Our Reference: SYD16/01263/03 (A17798398)  
DP&E Reference: SSD 7968

**ALTERATIONS AND ADDITIONS TO EXISTING EDUCATION ESTABLISHMENT AND  
CONSTRUCTION OF NEW EDUCATIONAL ESTABLISHMENT – ORAN PARK HIGH SCHOOL  
AND ORAN PARK PUBLIC SCHOOL – 400F THE NORTHERN ROAD, ORAN PARK**

Roads and Maritime has reviewed the submitted documentation and provides the following comments for your consideration in the determination of the application:

CONSTRUCTION TRAFFIC
MANAGEMENT PLAN

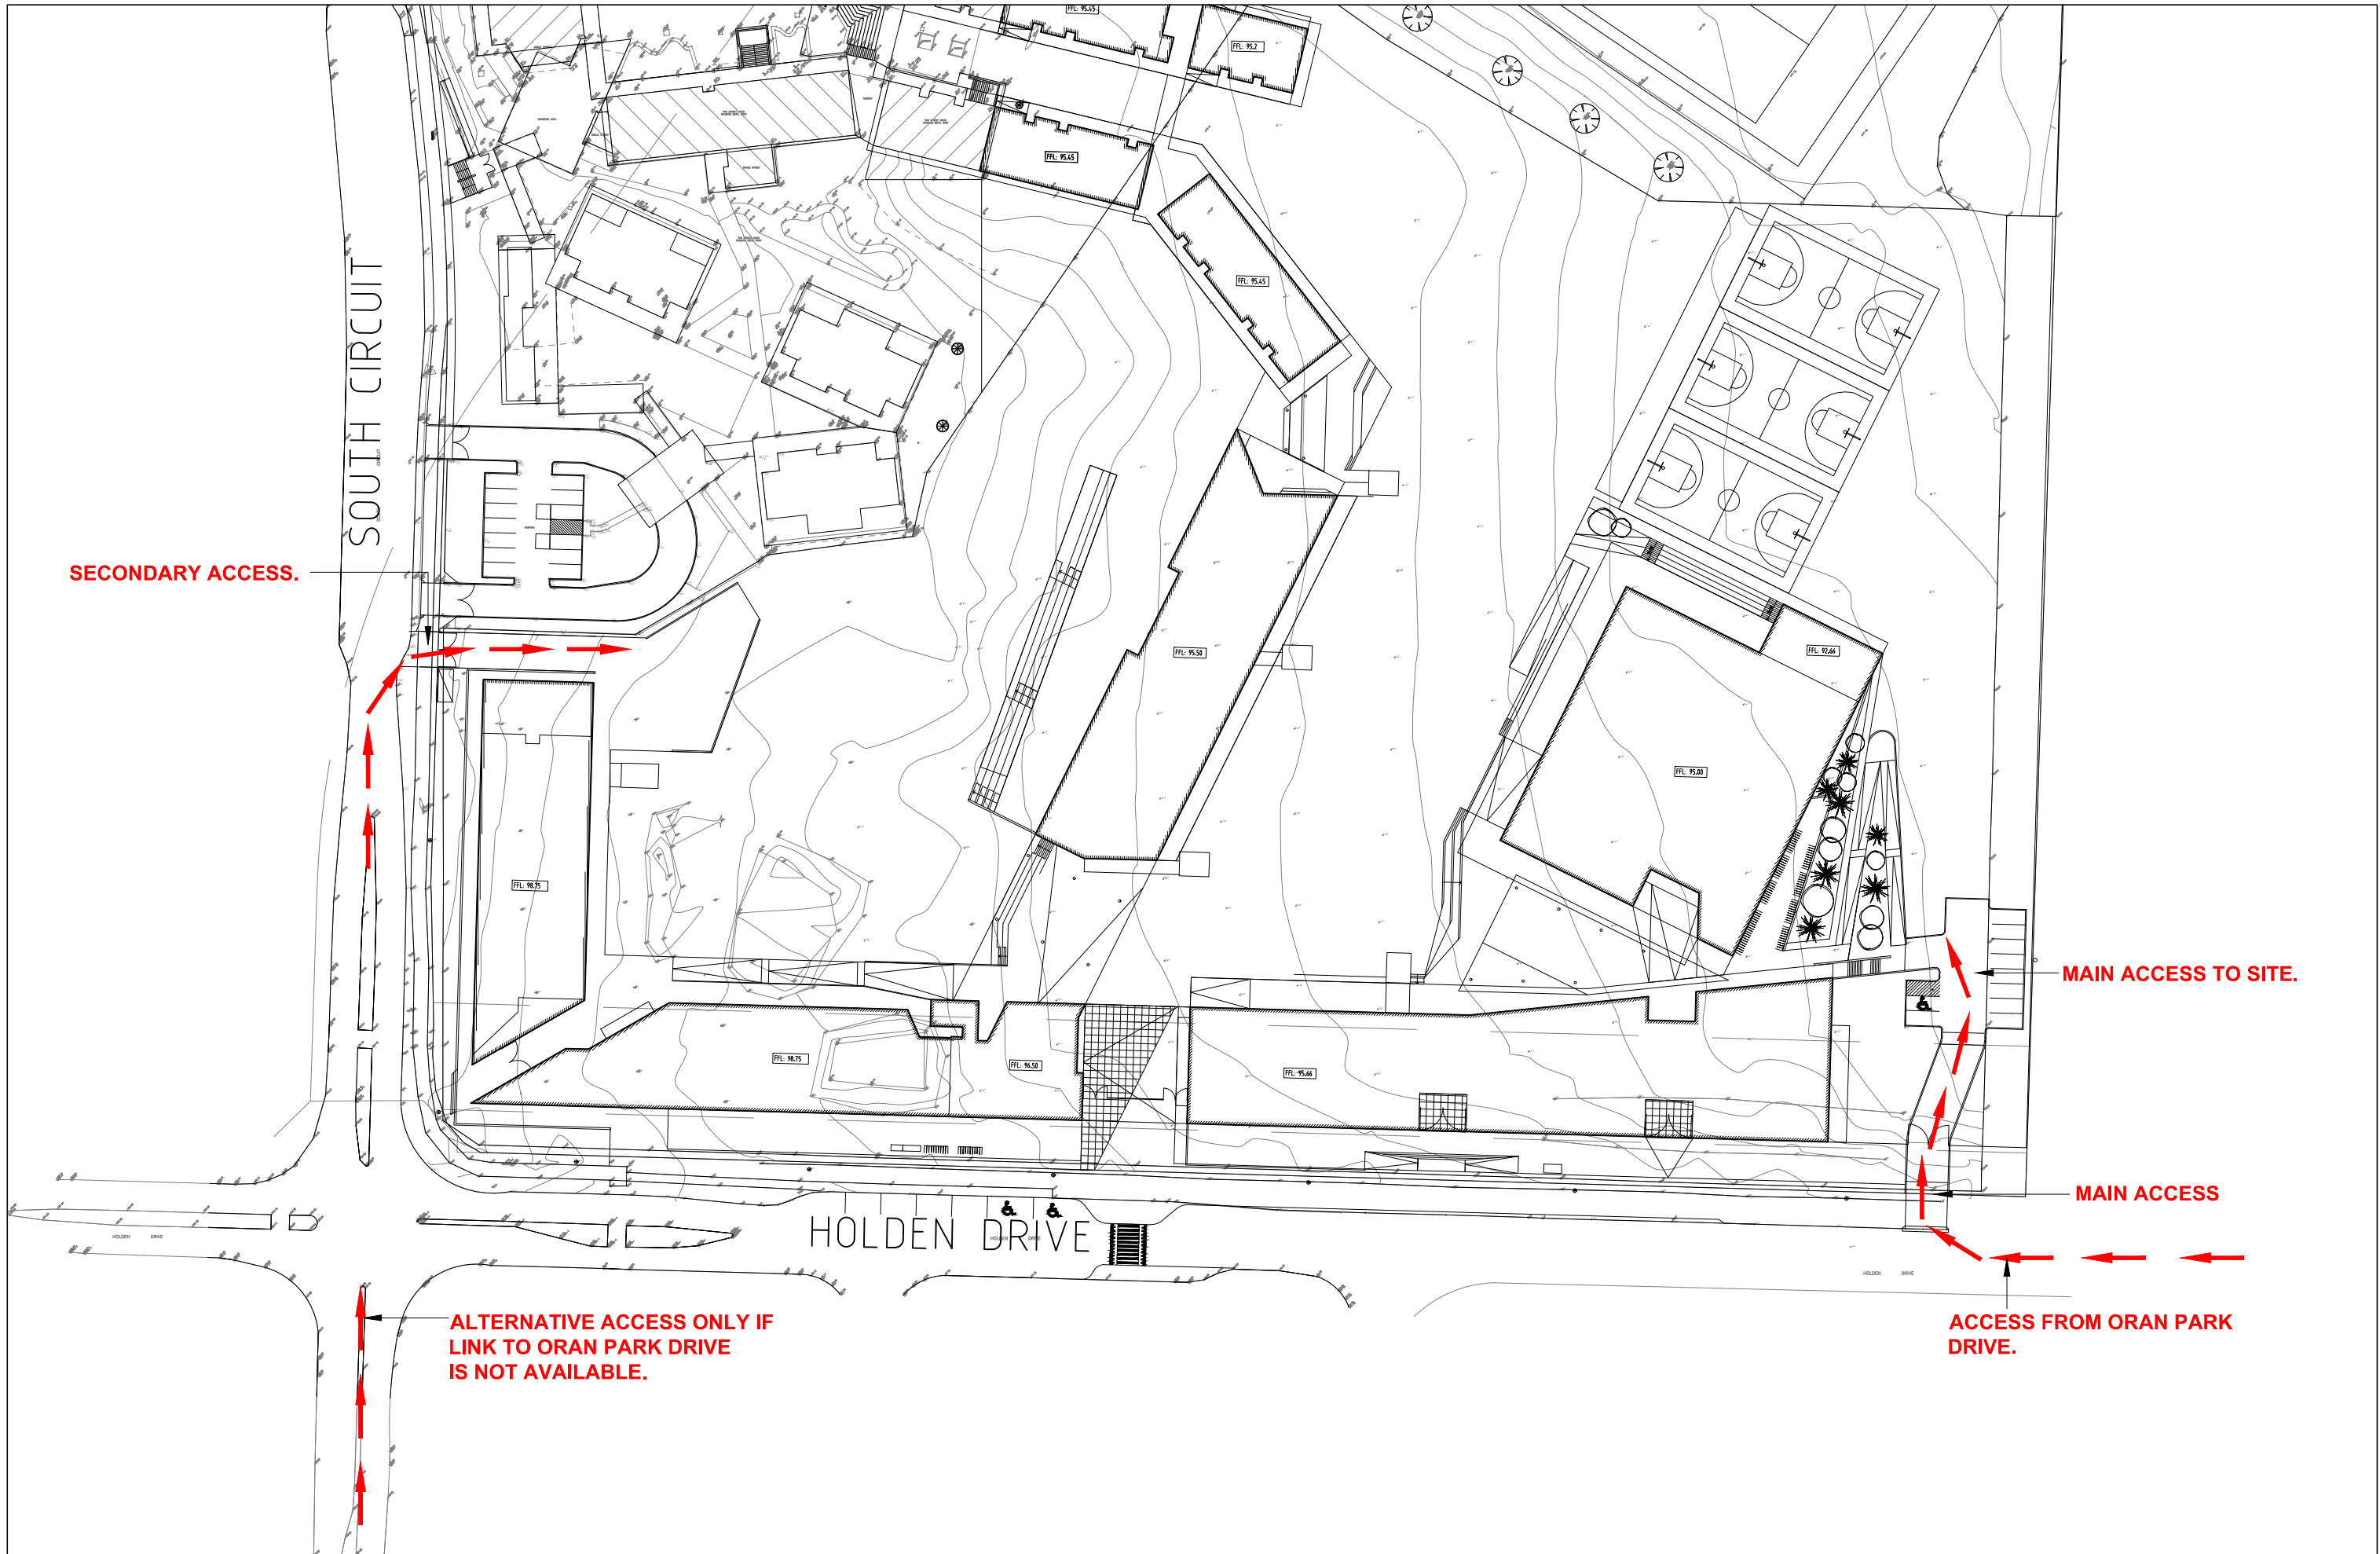
- 6. A Construction Traffic Management Plan detailing construction vehicle routes, number of trucks, hours of operation, access arrangements and traffic control should be submitted to Council for approval prior to the issue of a Construction Certificate.
